RE: HOMESTEAD FILING 2 – PRELIMINARY ACCEPTANCE PUNCHLIST FOR FULL SPECTRUM DETENTION POND 1

RE: HOMESTEAD FILING 2 – VOLUME CERTIFICATION LETTER FOR FULL SPECTRUM DETENTION POND 1

RE: HOMESTEAD FILING 2 – PRELIMINARY ACCEPTANCE PUNCHLIST FOR NORTH SAND FILTER BASIN

24" OUTFALL INTO SAND CREEK
1"=5'

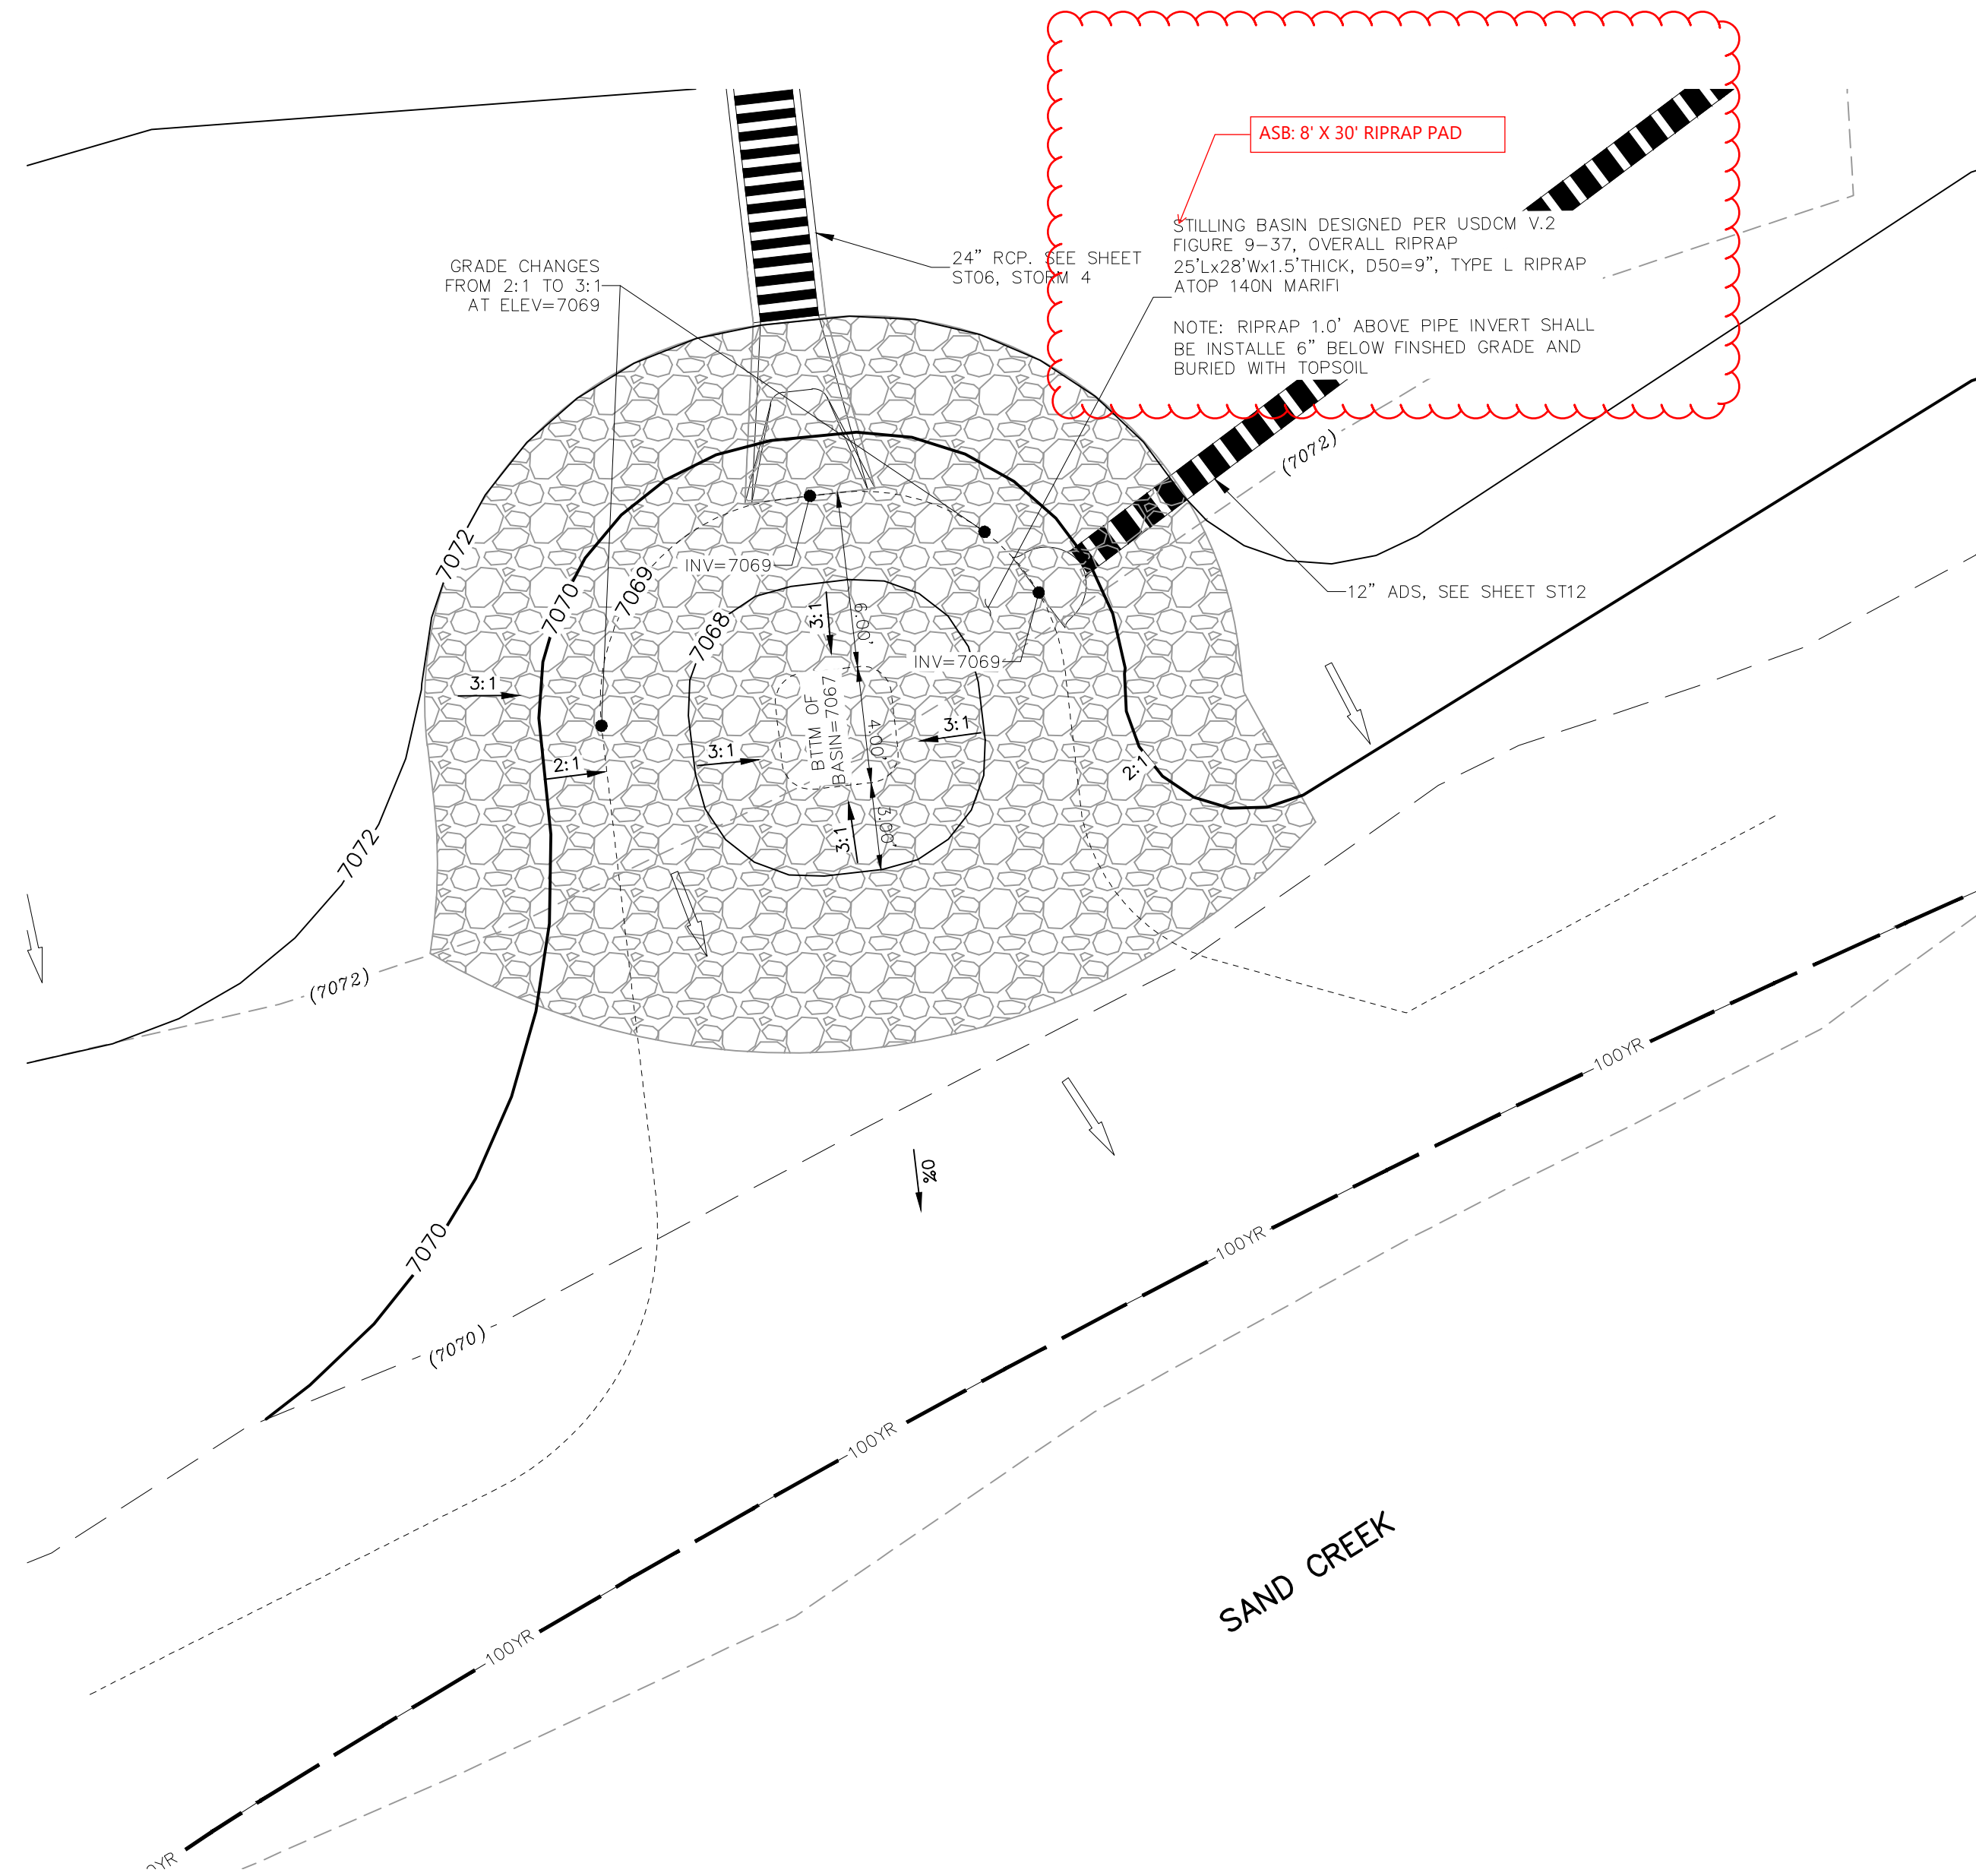
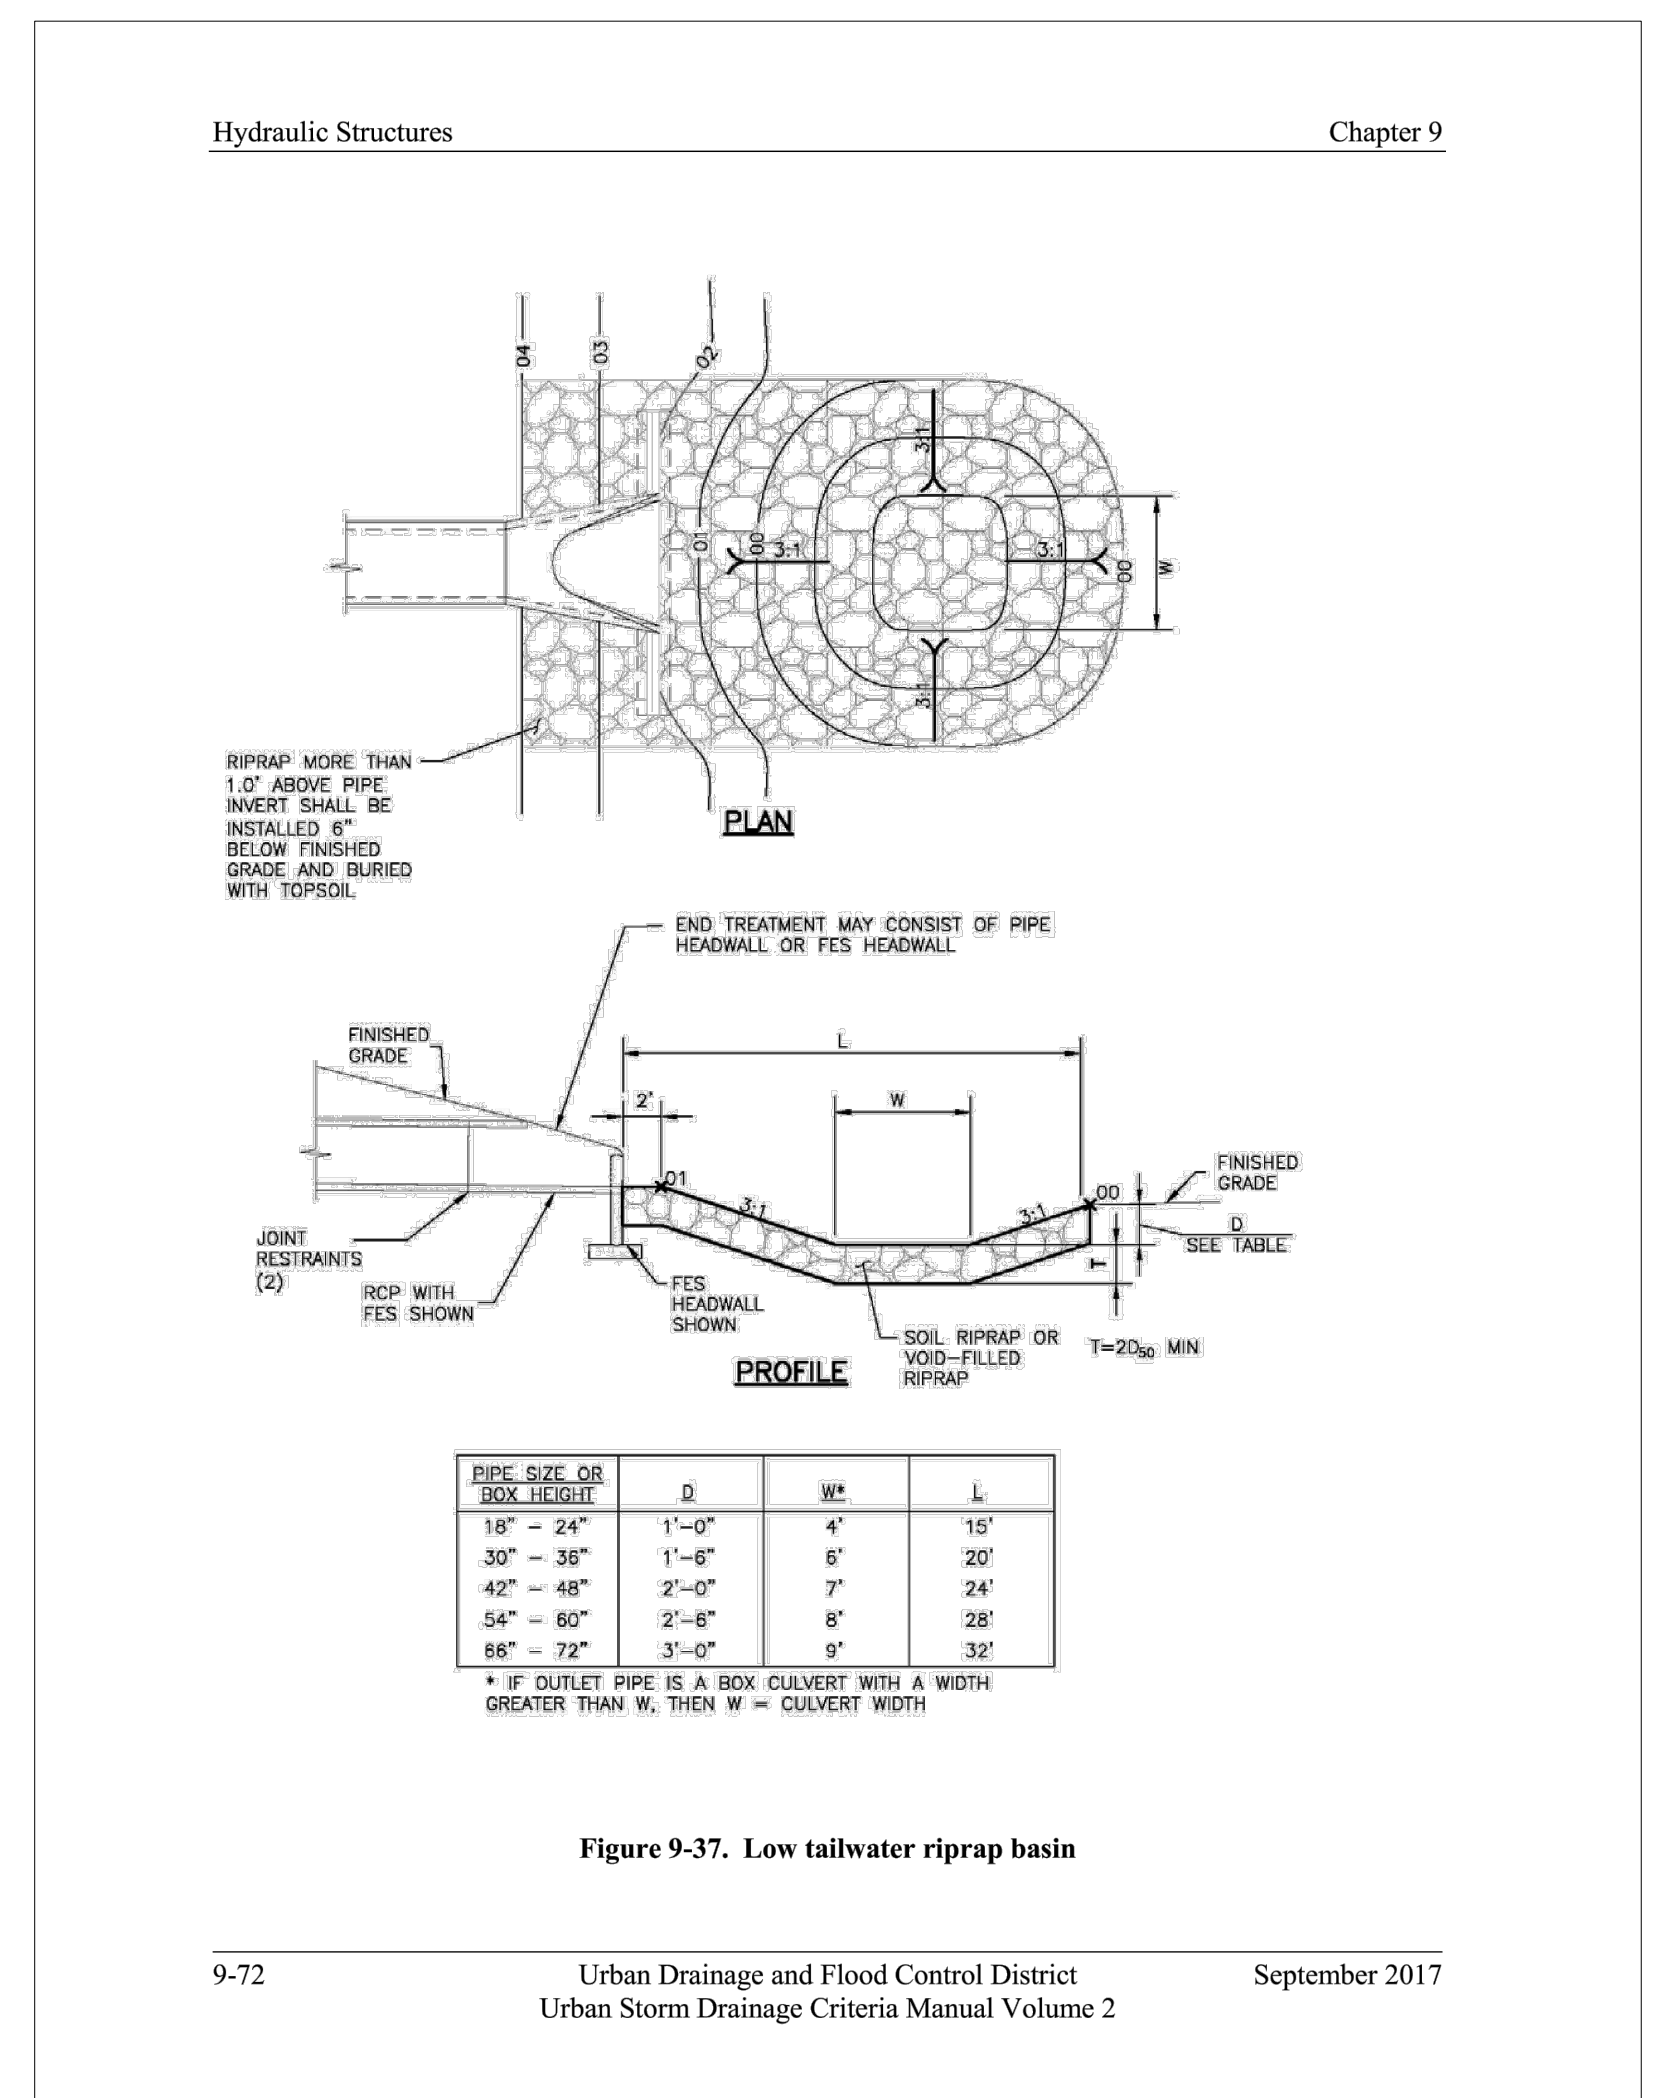
Pond Outfall

The pond outfall was constructed with an 8' x 30' Type L riprap pad. The riprap pad provides the necessary energy dissipation for the pond outfall. See attached riprap sizing for verification. This as-built condition is temporary, as the outfall will be modified to discharge onto a grouted boulder drop-structure with the Sand Creek Channel Improvements. Therefore, I recommend that the riprap pad as constructed be accepted as the Pond 1 outfall erosion protection. A concrete cut-off wall is not necessary in our opinion. Any undermining should be filled with Type L Riprap, should it occur. We believe the observed undermining was a result of incomplete riprap placement.
